13 January 2010

NB11167 - Rippon Grange Peer Review - r00.docx

'Rippon Grange' private hospital traffic, parking and access review

Swept Path - Plot 1
8.8m MRV
Prepared by TRAFFIX
4th March 2009
Scale~ 1:200 @A3

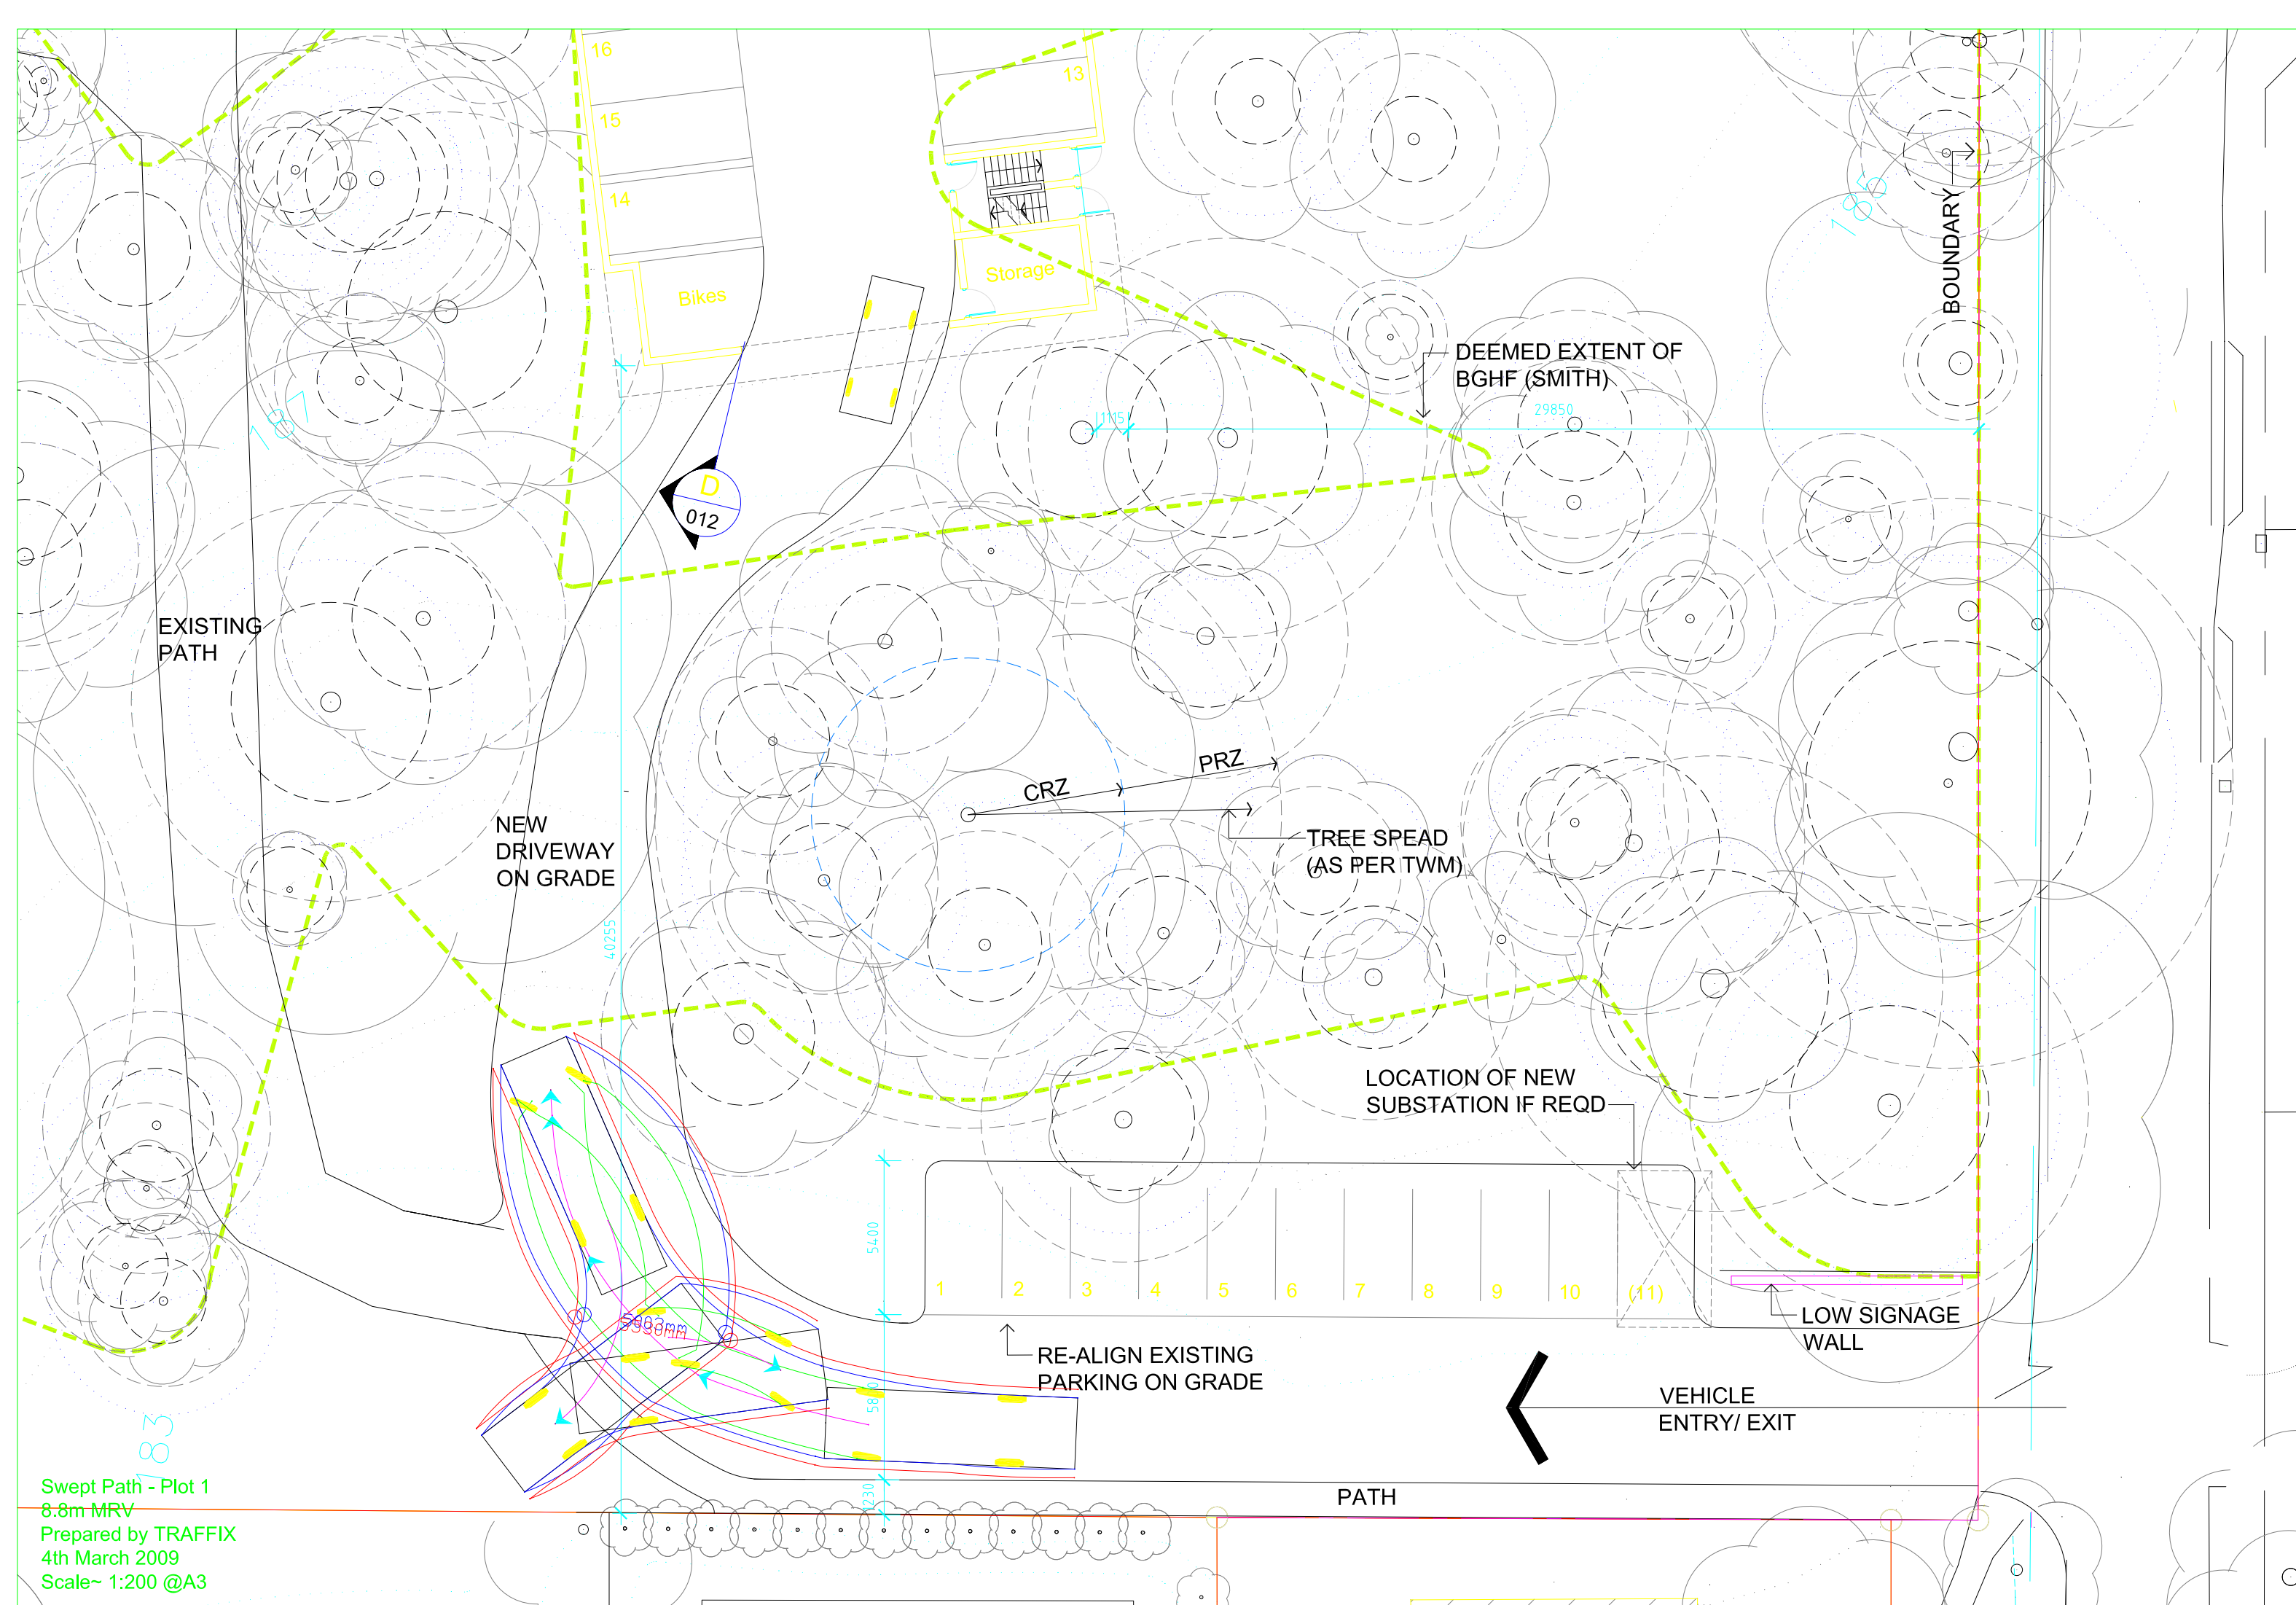
A review of the design drawings (including swept paths) contained in the traffic impact assessment indicates that there is sufficient space for a medium rigid vehicle (8.8 metres in length) to manoeuvre within the main designated loading area to enable entry and exit in a forwards direction. Furthermore, the proposed driveway design and layout on Water Street (which will be the main point of access for service vehicles) is considered adequate. However, it is noted that the swept path for an 11.0 metre-long vehicle is provided, which is not a standard design vehicle. A heavy rigid vehicle (12.5 metres in length) will not be able to be accommodated, either in the driveway or within the site. Further clarification is required.

A swept path diagram for a medium rigid vehicle is provided for an area approximately 40 metres west of the Young Street access. However, the purpose of the diagram is unclear, as there are no loading areas in the vicinity. Furthermore, the diagram suggests that reversing the vehicle (to enable exit from the site in a forwards direction) will result in mounting of the kerb line. Further clarification is required.

- Widen Young Street to 7.5 metres between the site access and Billyard Avenue;
- Adopt the RTA requirement of 112 car parking spaces rather than the 92 spaces specified by Ku-ring-gai Council's Parking DCP 43;
- Prepare a Construction Traffic Management Plan that details the following (but not limited to):
 - Main construction activities;
 - Construction staging;
 - Construction vehicles, including haulage routes, construction employees and access to adjacent properties;
 - Impacts on existing roads and accesses;
 - Traffic control plans; and
 - Safeguards and mitigation measures.
- Clarify the use of a non-standard design vehicle in the swept path analysis for the Water Street driveway; and
- Clarify the location of the loading area near the Young Street access, and whether egress in a forwards direction from the site at this location is possible for a medium rigid vehicle.
